Newcastle Grammar – Landscape Response to Submissions

Government Architect – SDRP Item 2

Government Architect – Advice of EIS Item 4c.

NEWCASTLE GRAMMAR SCHOOL PARK CAMPUS
DEVELOPMENT APPLICATION
REVISION F - RESPONSE TO SUBMISSIONS

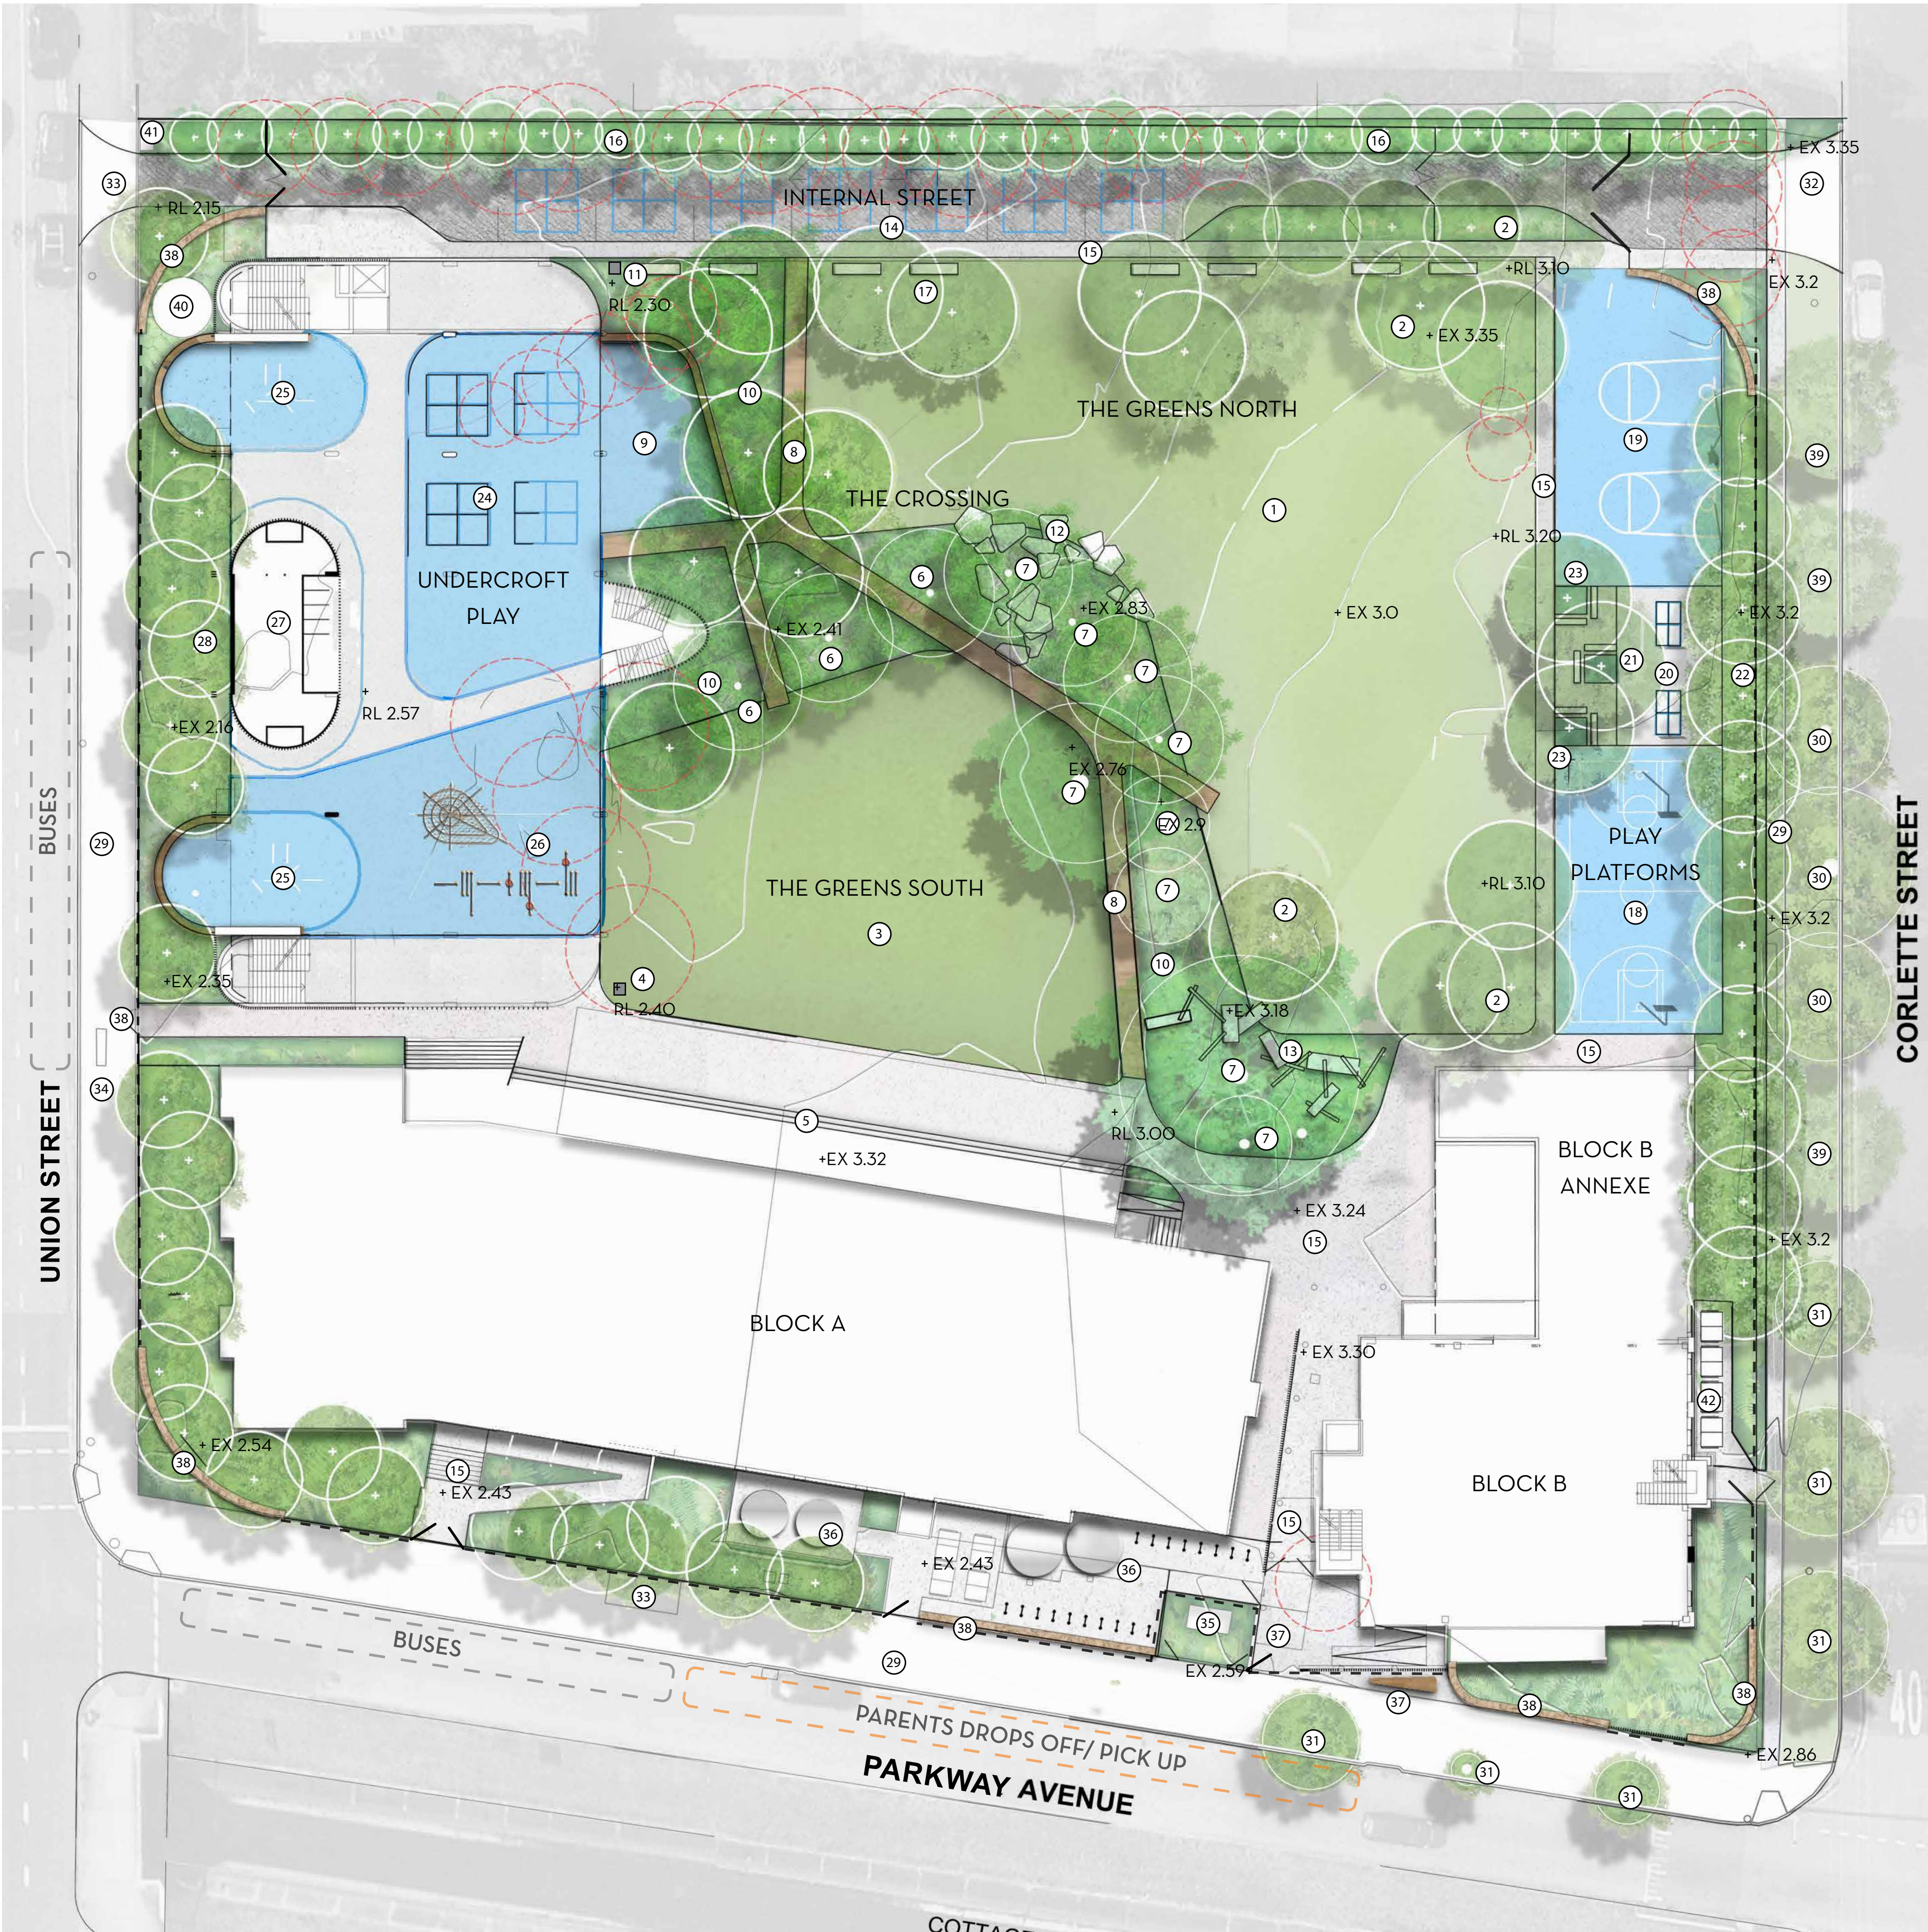
c. Refine the placement of the western boundary trees to reflect a relationship with the proposed stage 1 building. For example, the trees could align or deliberately misalign with the arches and parabolas.

Tree planting of *Banksia serrata* and *Banksia robur* together with understory species are proposed along the western frontage of the school facing Union Street. The intent of their placement deliberately does not reflect the arrangement of the building. Trees have been placed to provide a consistent visual buffer between the undercover play space and Union Street. The Undercroft play and learning spaces partially extend out beyond the roofline of the proposed building. The continuous canopy of the Banksias protects these spaces from harsh western sun along this frontage while offering a level of privacy from Union Street.

STAGE 1
UNION STREET BUILDING

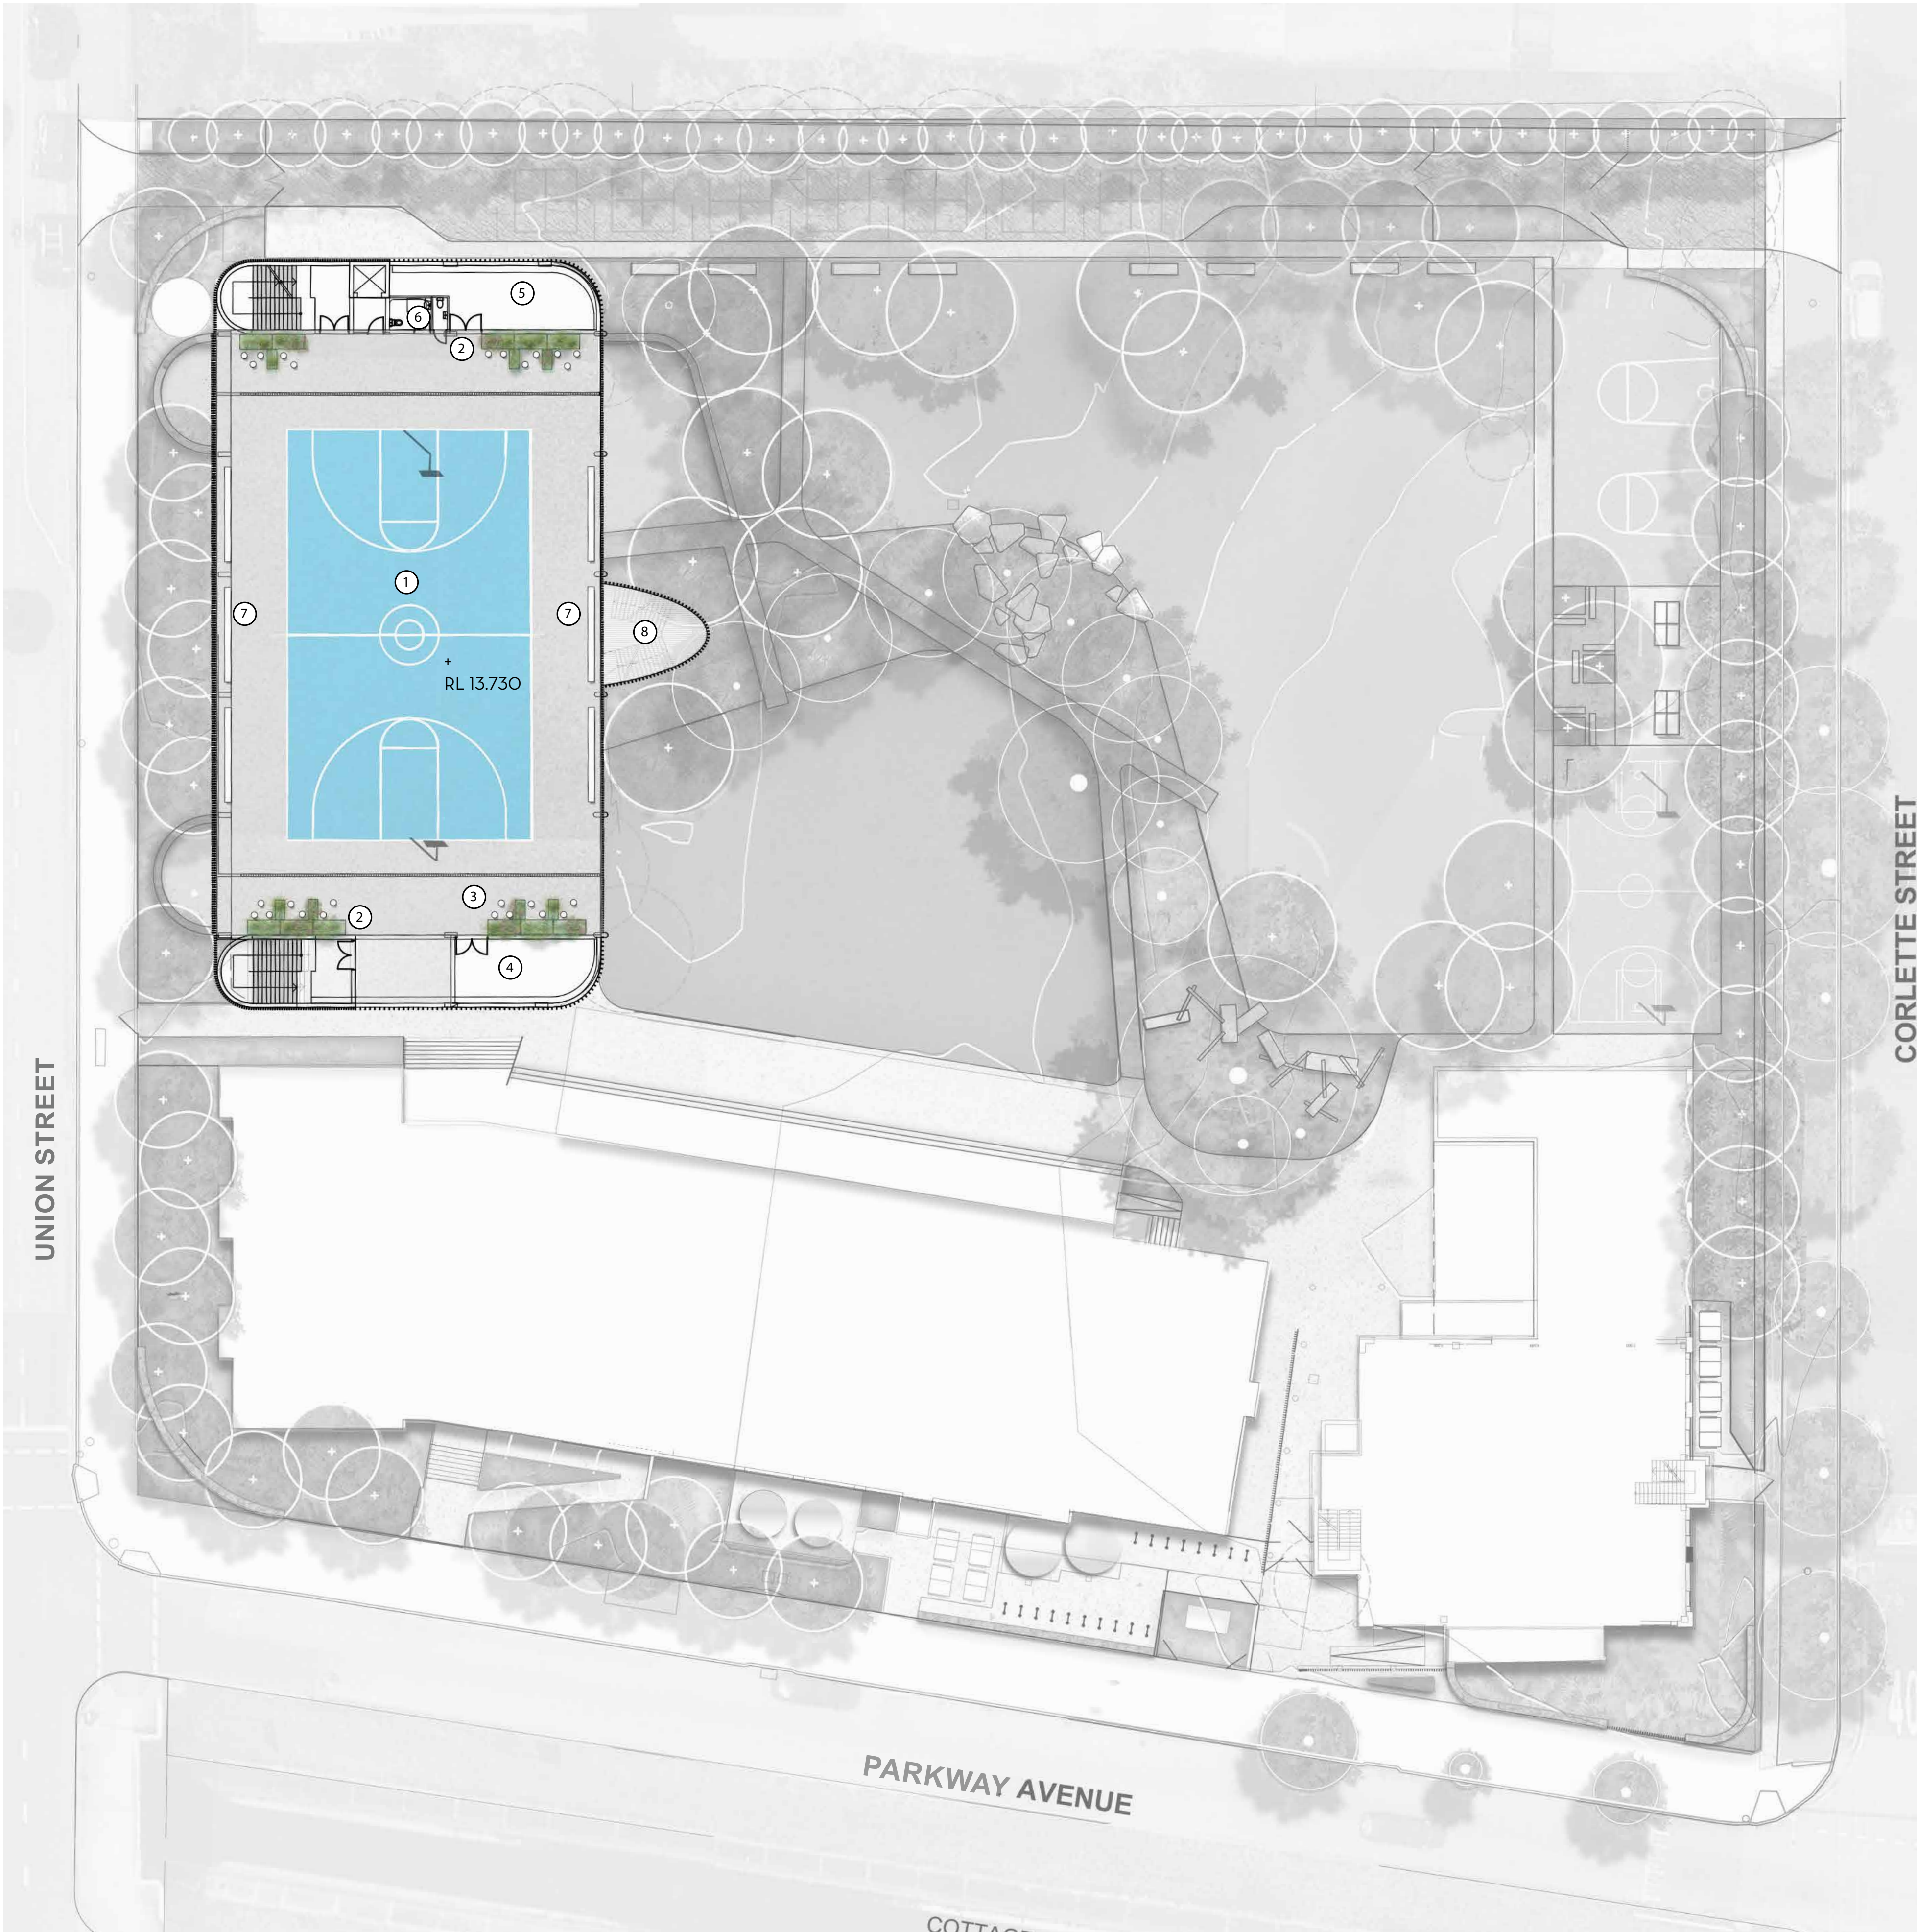
2. The proponent should clarify if the location and design of the bush tucker garden have been discussed and developed with the local Aboriginal community. Additionally, please ask them to explain if the bush tucker garden on the rooftop is protected from the sports court with netting?

Planting on the rooftop adjacent to the basketball courts will consist of robust and hardy species some of which are included within the plant list above such as *Lomandra tanika*, *Correa alba* and *Westringia fruticosa*, planted within raised planters. These species will tolerate occasional impacts from ball games played by primary school aged children therefore it is not envisaged that specific screening / netting be provided between the planting and the courts.
